ABP-314724-22

For: Railway (MetroLink Estuary to Charlemont via Dublin Airport) Order Application

An Taisce

The remainder of our submission today, concerns options for the Tara Station due to considerations about the loss of community infrastructure and city centre residential accommodation.

TARA STATION

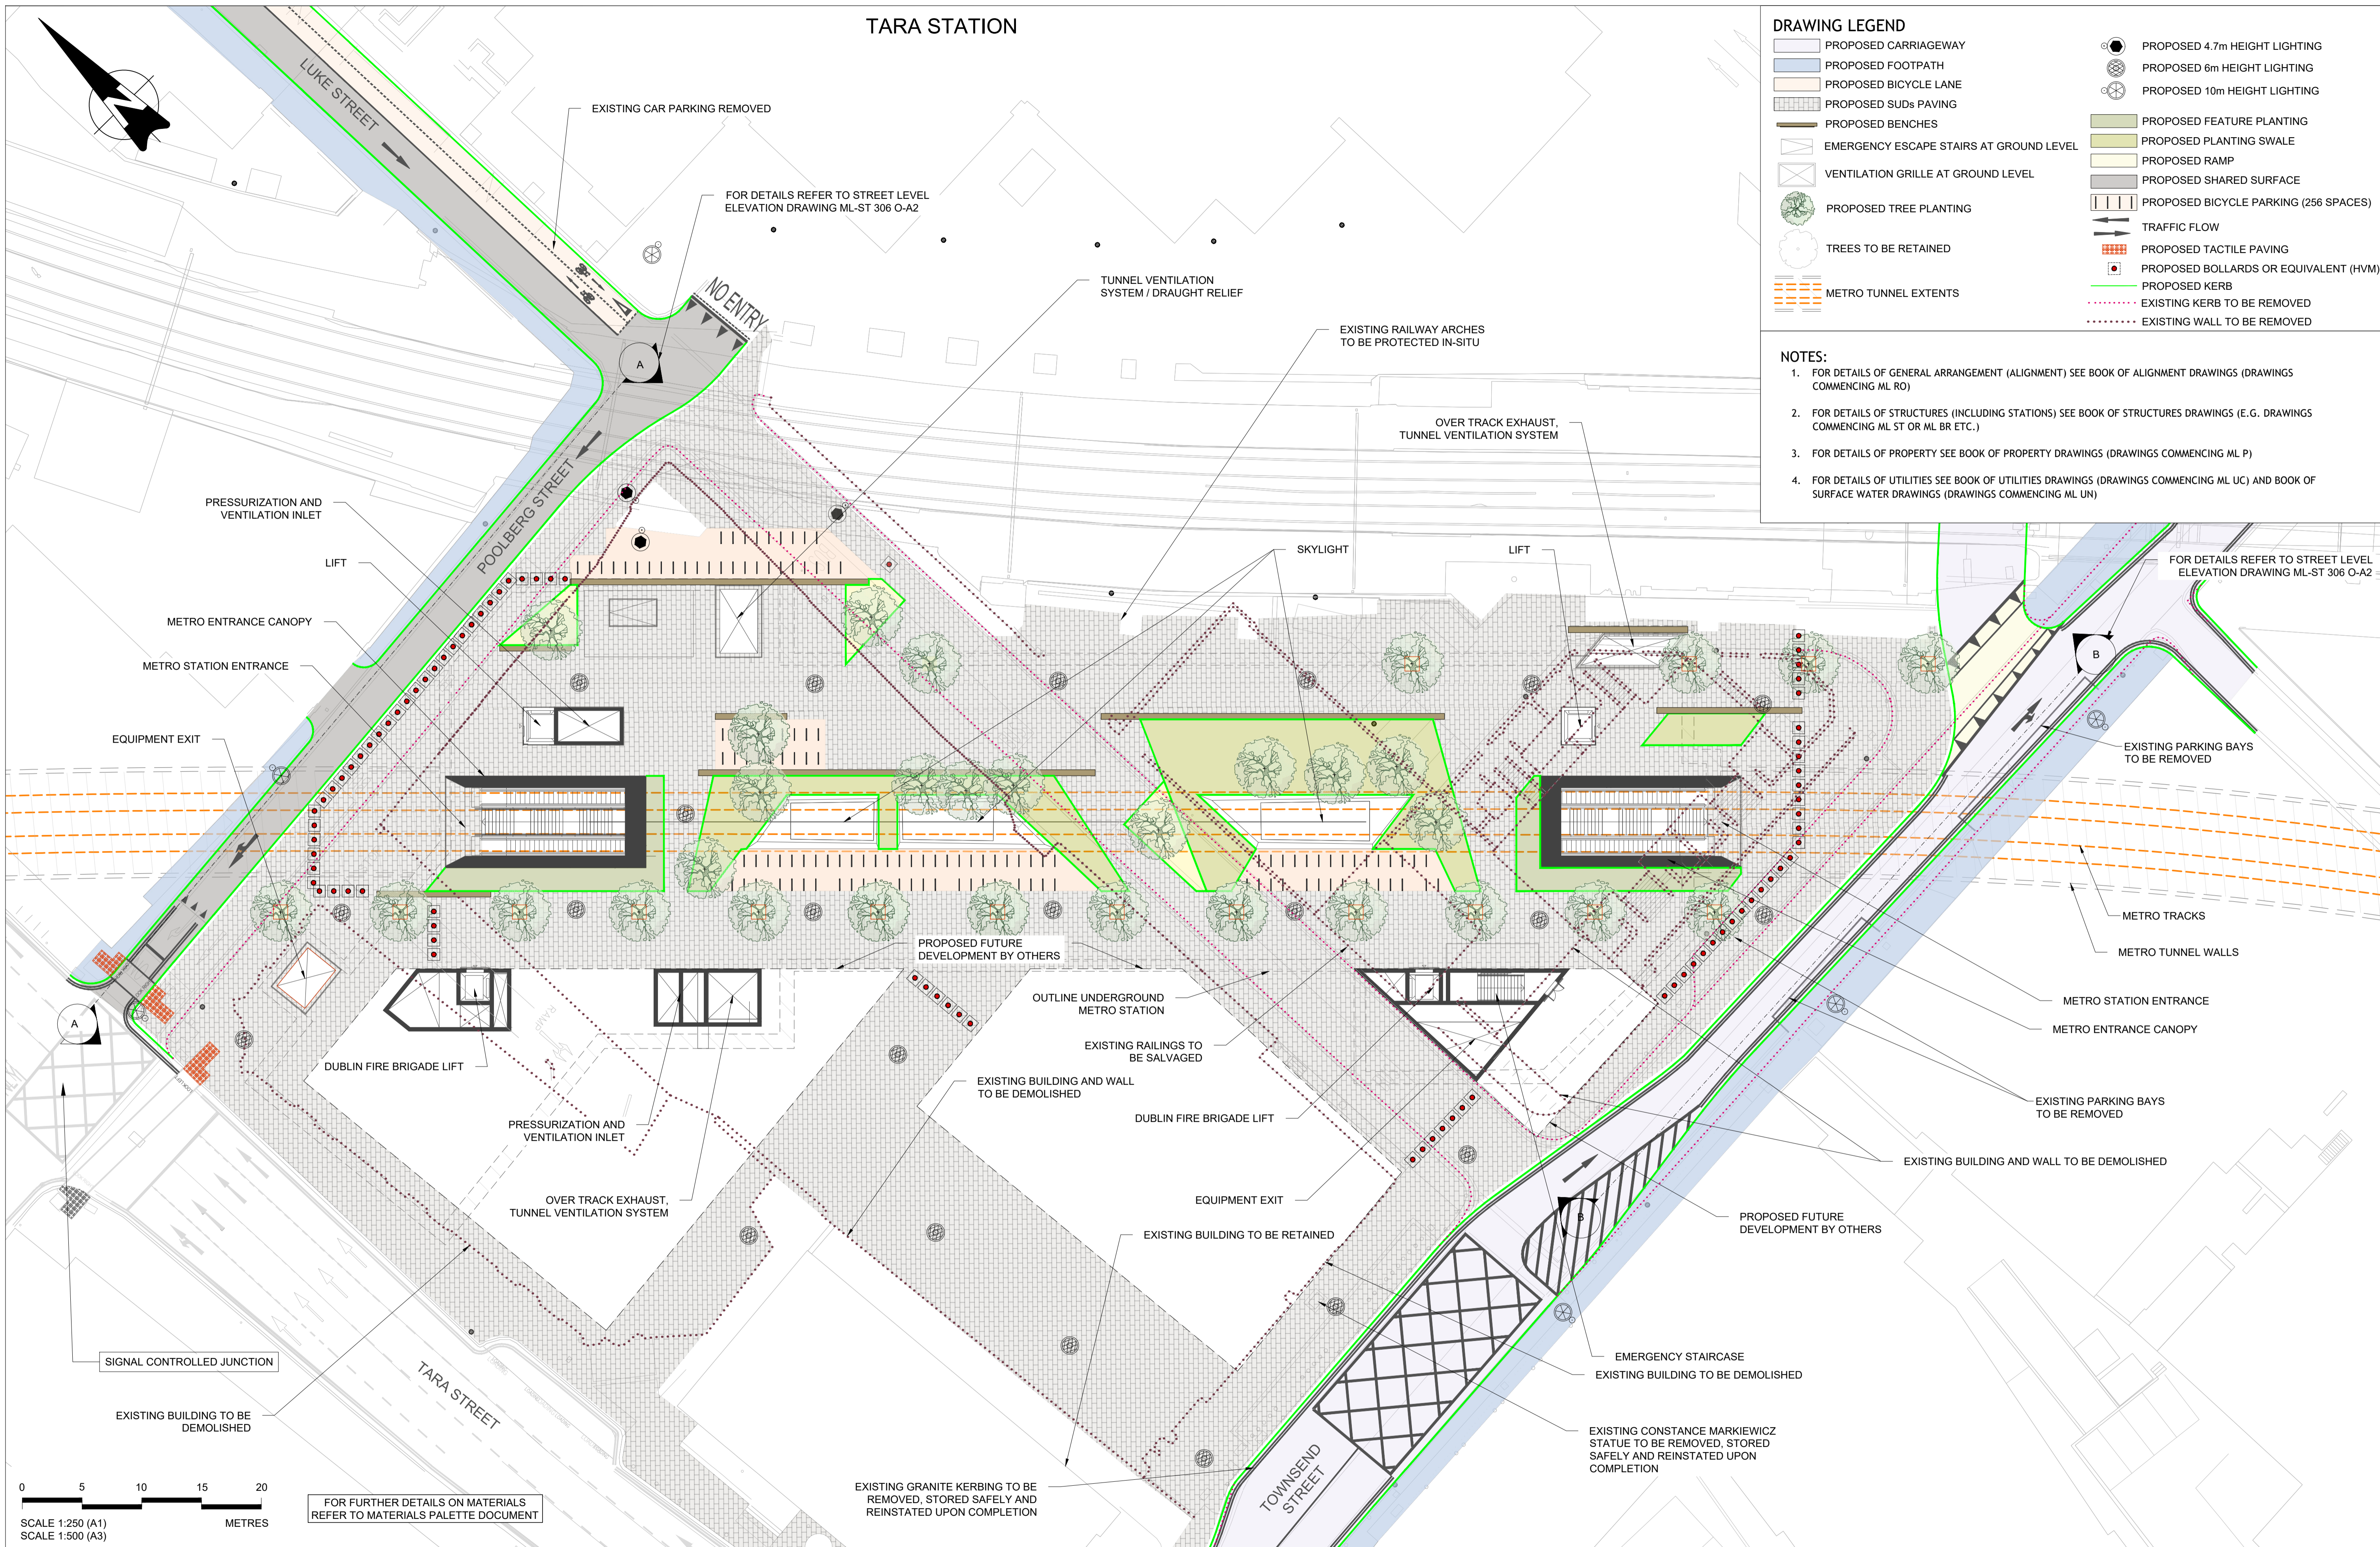
In the final recommendations in the Multi-Criteria Analysis, although both the selected Cut and Cover - OPTION 0 and mined cavern - OPTION 4 were given similar (amber colour), we would query why OPTION 0 was indeed selected, when this selected option would exact a substantially higher human cost than Option 4, including, although we do understand that both options would result in the loss of 8 DCC-owned Duplex units on Townsend Street.

The human cost will include loss of Markievicz Leisure Centre, which can justifiably be described as critical infrastructure, as it is the only remaining publically accessible swimming pool in Dublin's South inner city, as well as being a heavily used sports amenity. The Markievicz, when taken together with its predecessor, the Tara Street baths has continuously served Dublin's inner city communities and workers in this location for the past 150 years.

It will also include the loss of the 70 apartments in the College Gate complex, which is taking place during Ireland's current housing crises. Therefore it is reasonable to suggest that some of the apartment buildings' 160 residents may face homelessness as a result of Transport Infrastructure Ireland's selection of the cut and cover construction methodology of the selected option.

Although in Multi-Criteria Analysis OPTION 0 is estimated to have construction costs of €139.9M, this does not include demolition and recycling costs and also does not include estimated relocation costs of the Markievicz to the Irish Town stadium of €48 M (according to DCC) and approximately €35 M compensation costs to the owners of the 70 apartments in College Gate (estimated at €500K per unit) which would be a total of € 222.9M, which is € 61.2 M more than the applicant's estimates of construction costs of € 161.7M.
